**MAJOR PROJECT ASSESSMENT:
UNIVERSITY OF SYDNEY FACULTY OF
LAW PROJECT**
*Proposed by Capital Insight Pty Ltd (on behalf
of the University of Sydney, Campus Property
and Services)*

Director-General's
Environmental Assessment Report
Section 75I of the
*Environmental Planning and Assessment Act
1979*

January 2007

**Building Envelope**

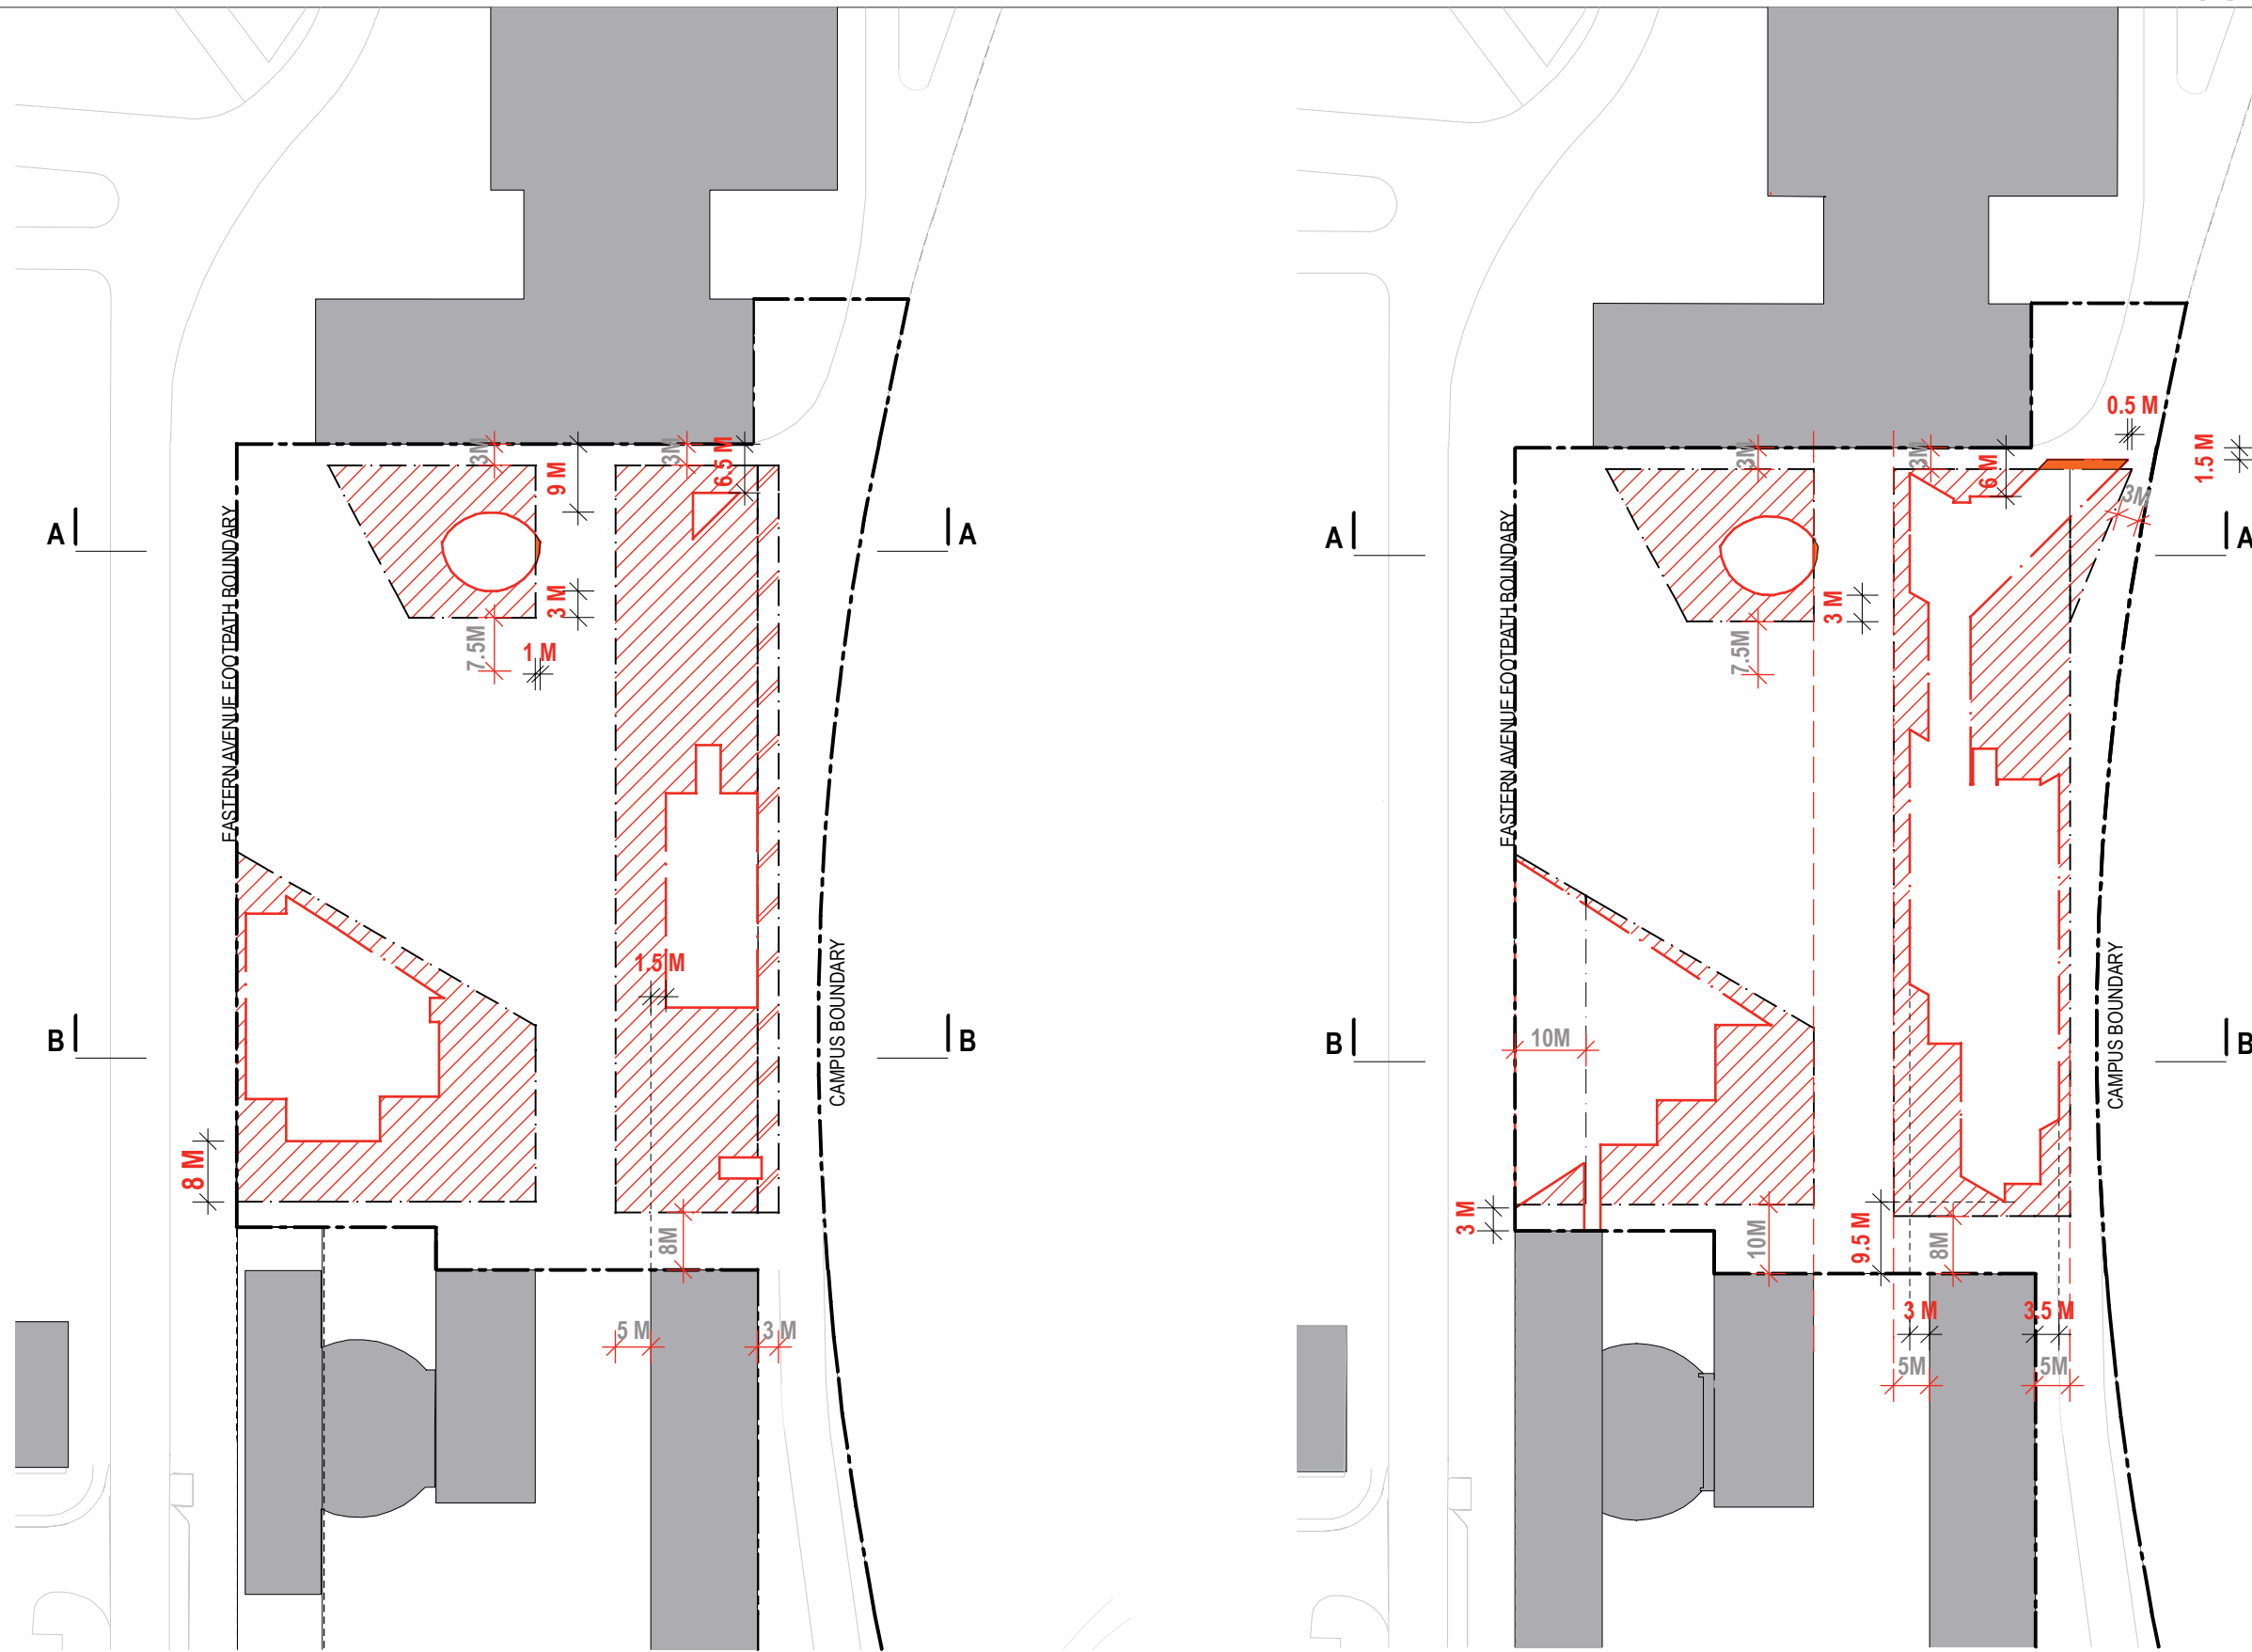
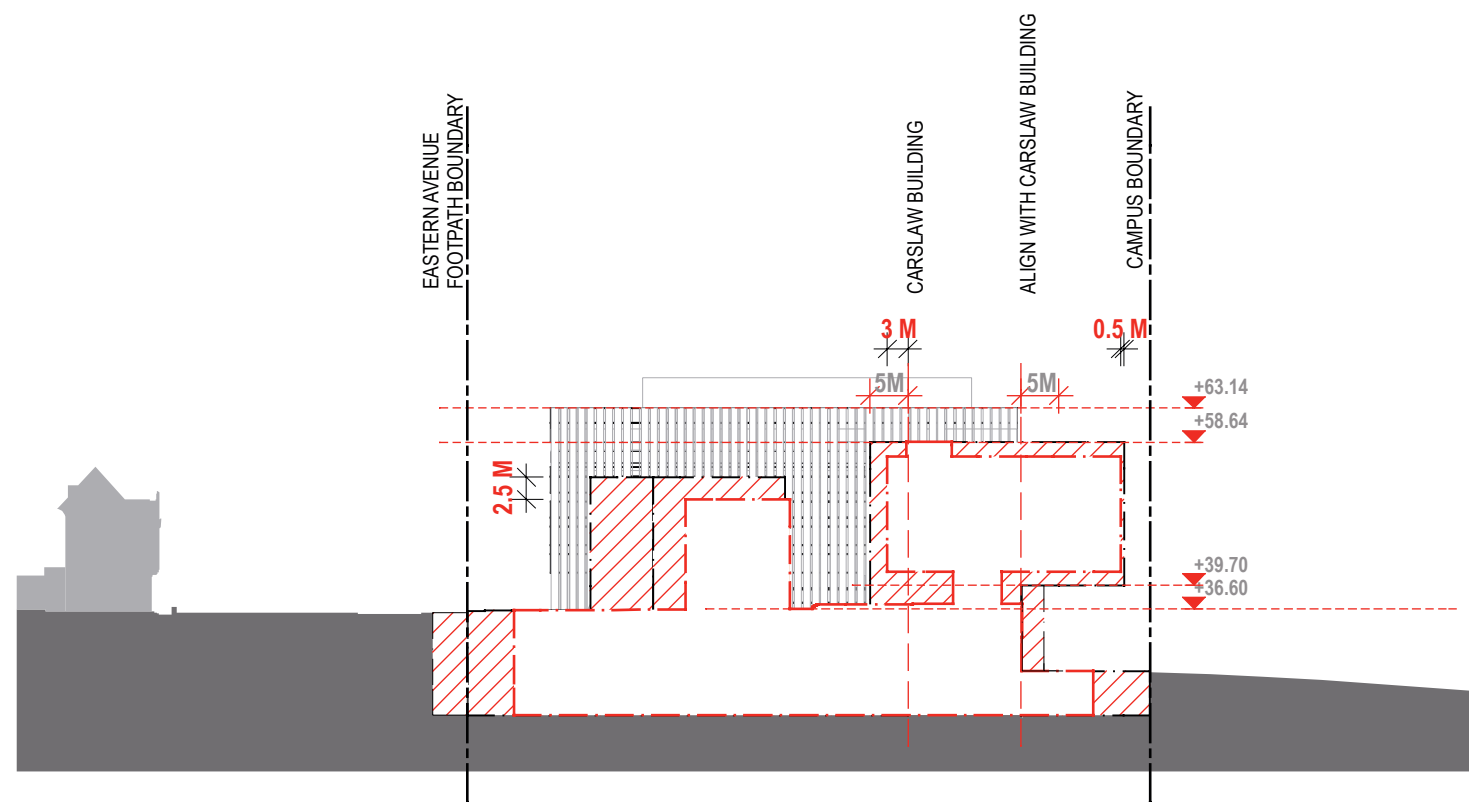
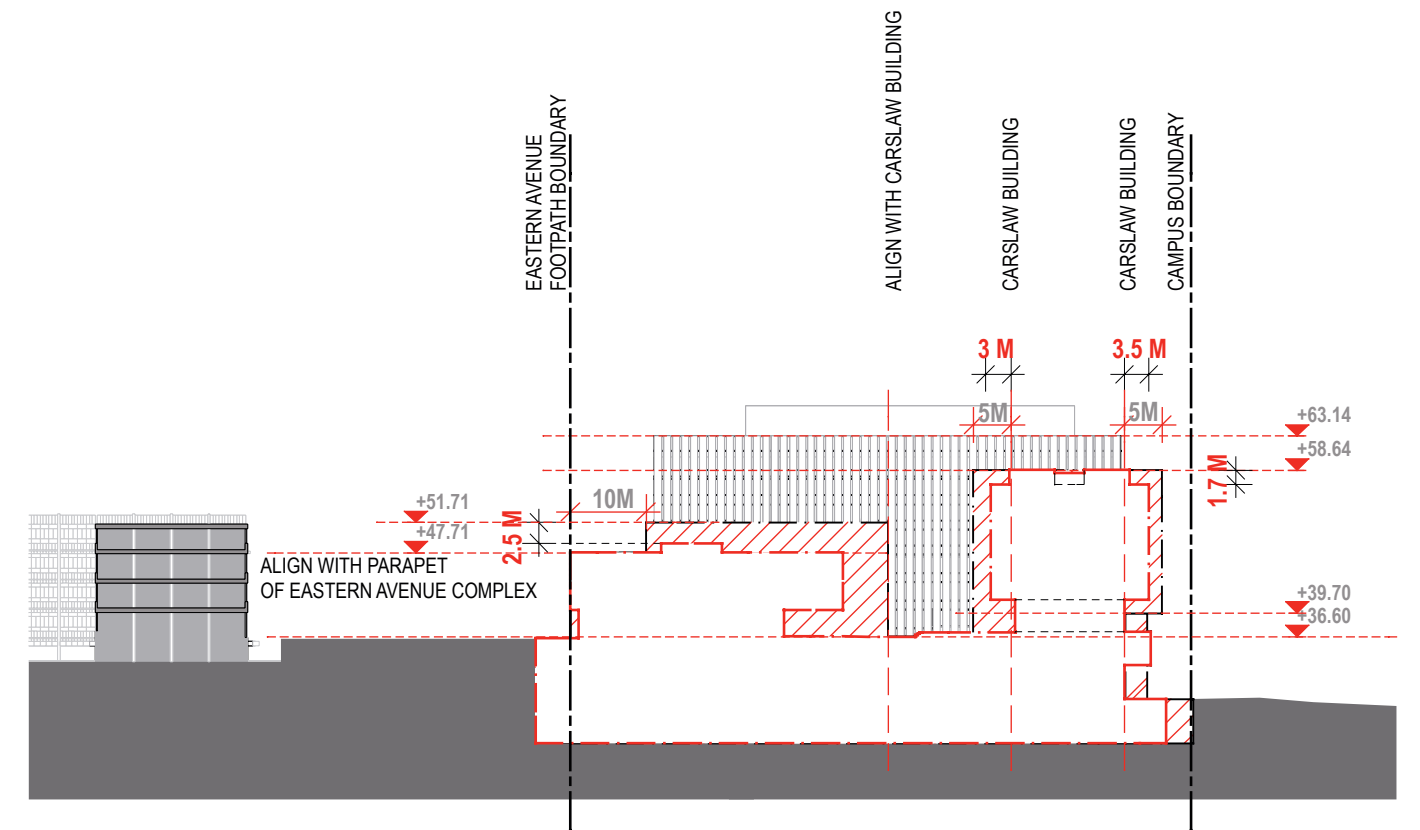
Issue: The proposed development has minor non-compliances with the building envelopes approved in the Stage 1 DA.

The proposed development encroaches on the building envelopes approved in the Stage 1 DA to a minor degree. Building non-compliances compared to approved Stage 1 DA envelope are as follows:

- A continuous roof ventilation element on the north-west part of the building on the Forecourt side - well set back from the Victoria Park facade - is 0.7 m higher. (Refer EA report section 171.203 and elevation 171.201, dated 23-9-05);
- Teaching building roof is stepped up 0.2m higher behind parapet zone. It is noted that the parapet is still aligned with the Eastern Avenue Auditorium and the Lecture Theatre Complex (Refer EA Report Appendix B, 16 March, section B); and
- Adjacent to the lift overrun, well set back from the Eastern Avenue façade, between grids 10-11, a part of the roof on top of the atrium is 18.50.

The non-compliances of the maximum RLs of the proposed development are as follows:

Approved RLs in the Stage 1 DA are: Faculty Building: RL 58.64; Teaching Building RL 49.21 for lift overrun, RL 47.71 for rest of building.

Proposed RLs for development are: Faculty Building: RL 58.64 – with the exception of the roof ventilation element above – RL 59.40; Teaching Building RL 49.21 RL 48.50 for rest of building.

Resolution: The abovementioned non-compliances are considered to be of minor nature and however do not result in any significant environmental impacts.

Upon Council's request, a condition of consent has been imposed requiring a report to be prepared by a suitably qualified person demonstrating the adequacy of the proposed mechanical plant atop the building so that the overall height of the building does not increase as a result of having to install additional plant at a later stage.
